**Consultation Response from KC,  
Lead Local Flood Authority**

**2025/93355 Land off, Woodward Court, Mirfield, WF14 0PY**

**Erection of 75 residential dwellings with associated landscaping, open space, highways and drainage infrastructure**

**Date Responded: 22<sup>nd</sup> March 2026  
Responding Officer: Paul Farndale  
Responding Ref:**

**FLOOD ROUTING PLAN**

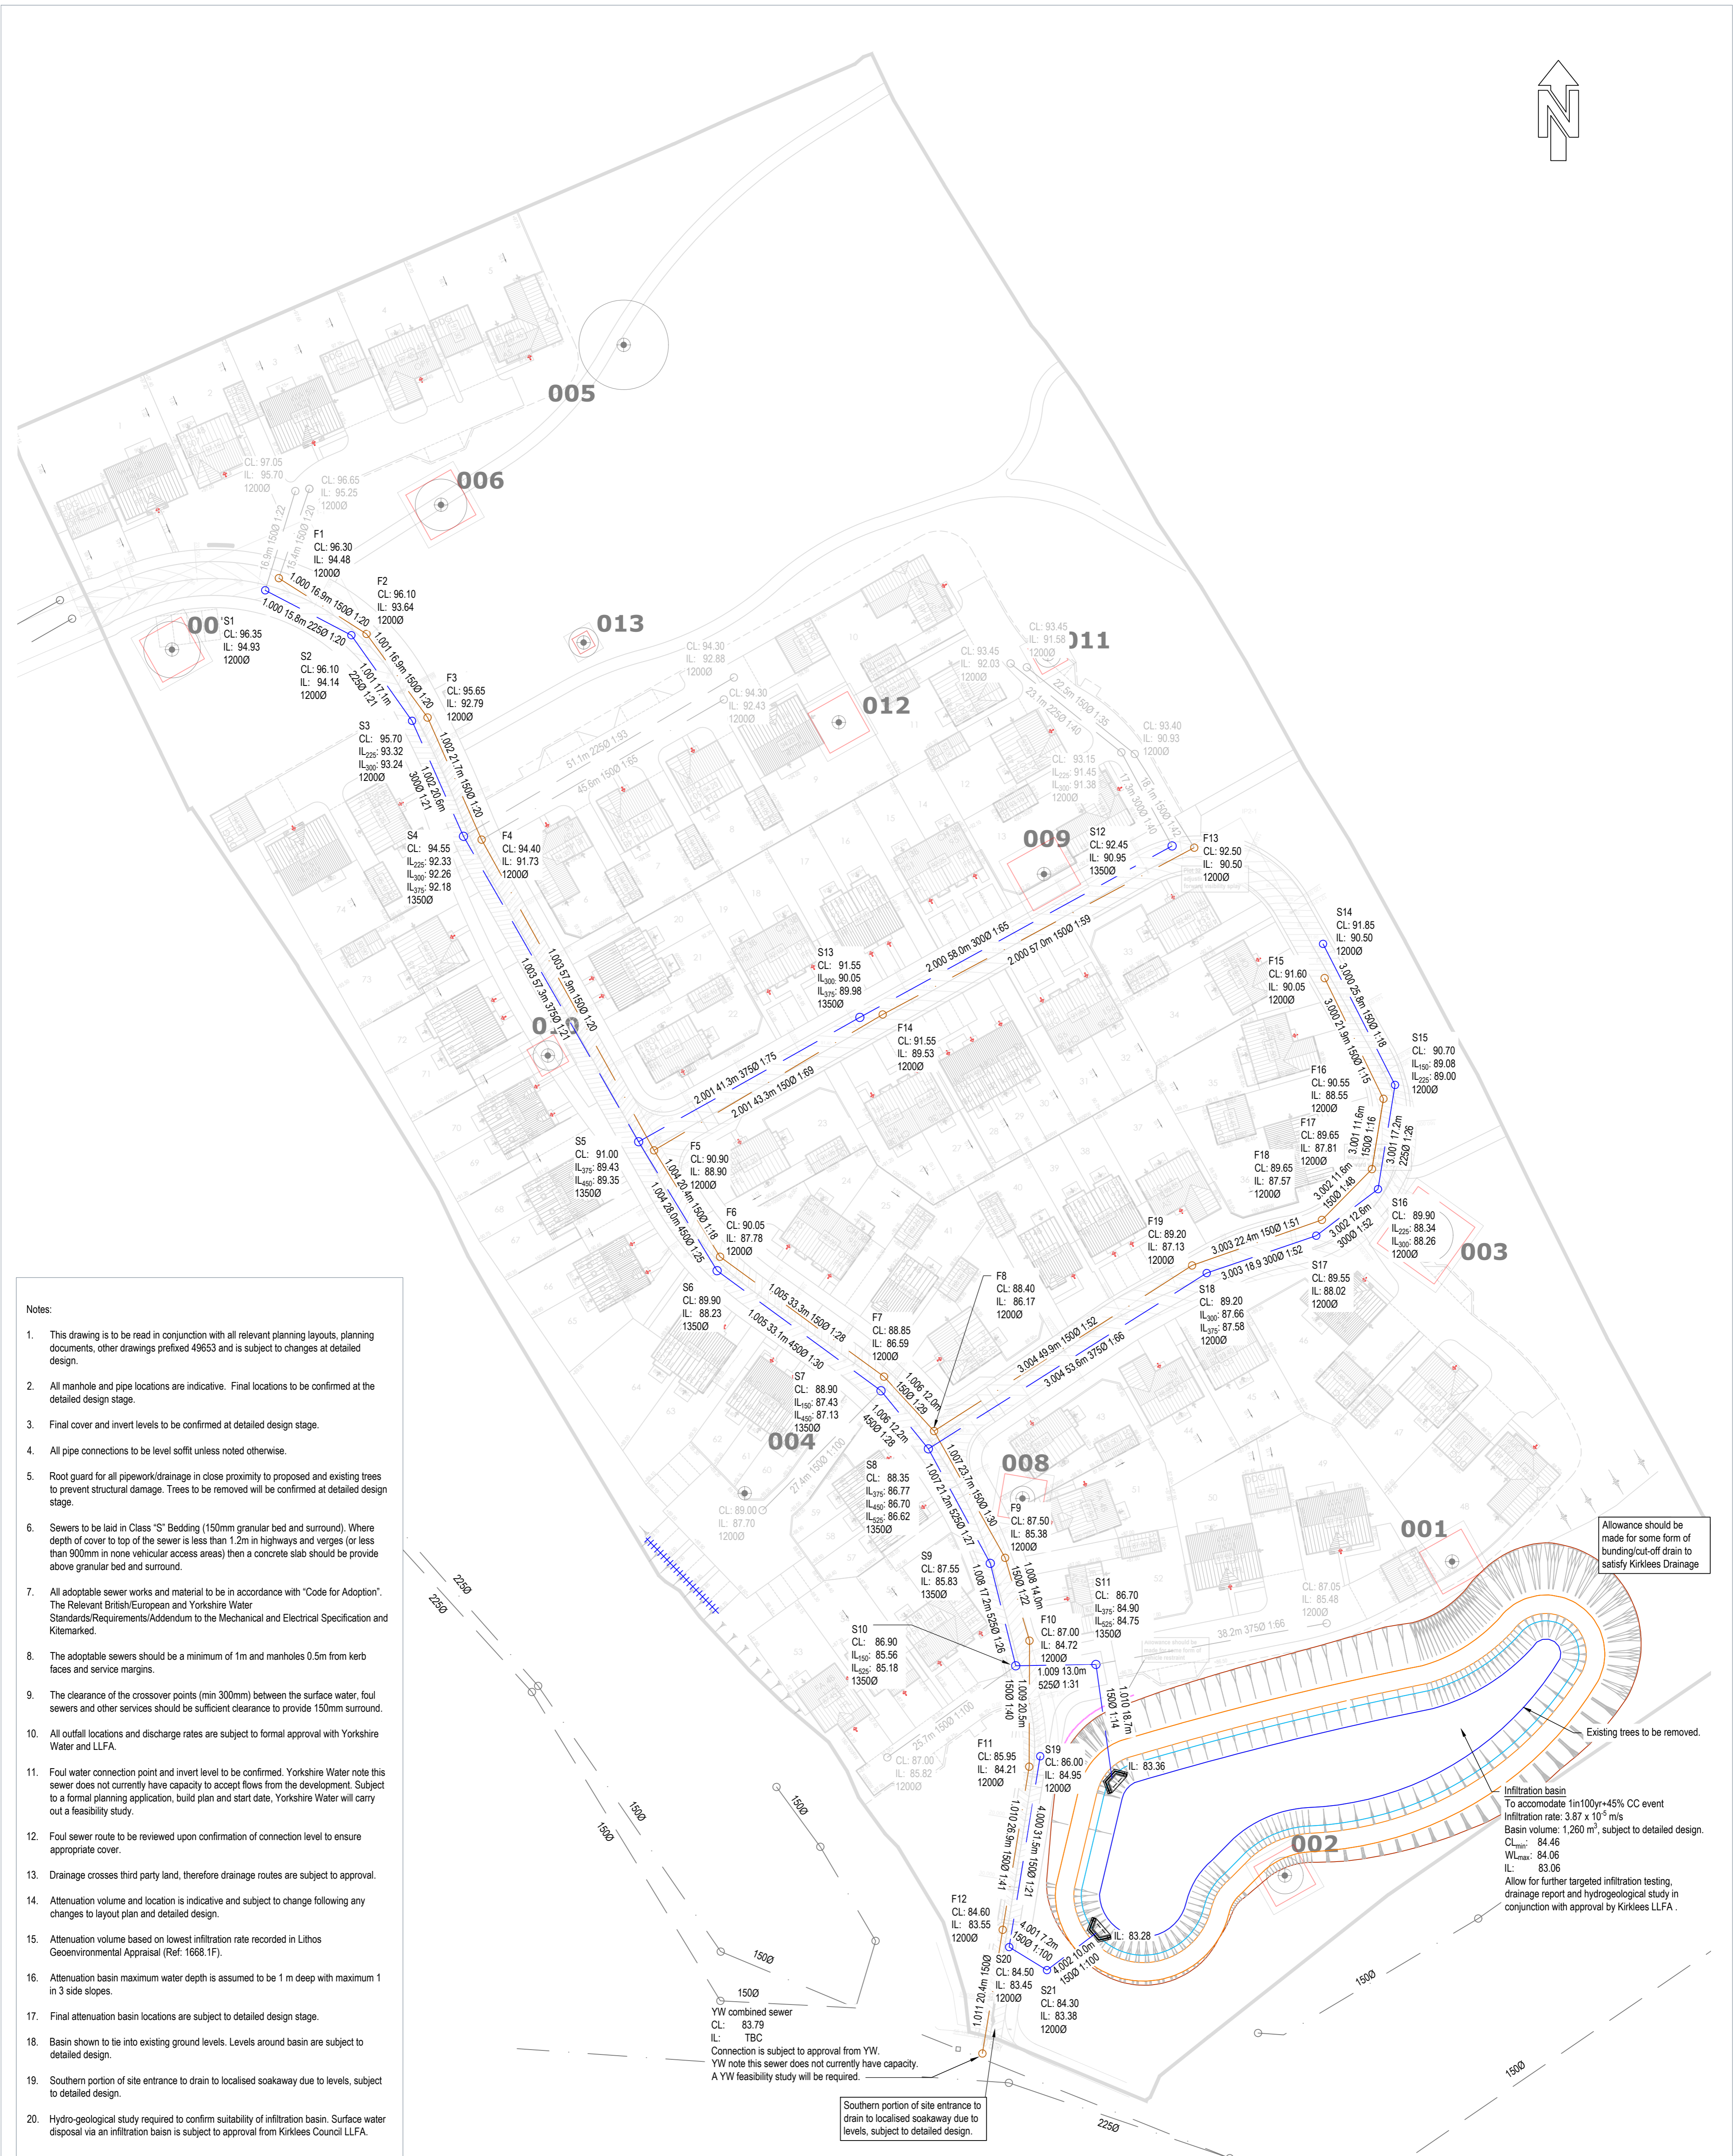
The planning officer must be certain soakaways can work and attention must be focussed on the nature of the substrata (after grouting has taken place). This site has shallow bedrock so there is no significant depth of free drainage material usually associated with good infiltration potential. In this scenario fissures in the bed rock are relied upon. In our experience, testing carried out in compliance with BRE Digest 365 can produce false results in this scenario.

If water levels in test pits reduce and give a good reading, it is possible that the limited volume used in such tests is moving laterally along the bedrock. A storm event where significant volumes of water land on whole site can give rise to re-emergence at lower levels as in a case study in Scholes, Holmfirth despite initial positive testing.

Using soakaways in linear pattern along a contour would reduce this risk as more fissures are likely to be picked up (soakaways were located in small isolated areas in the Scholes example). This still does not consider mine workings which could also give false results as a receptor, and the grouting to be carried out that alters sub-strata.

**We therefore recommend that the NATIONAL COAL AUTHORITY is asked to give a statement on their opinion of soakaways used on this site with regard to mine workings.**
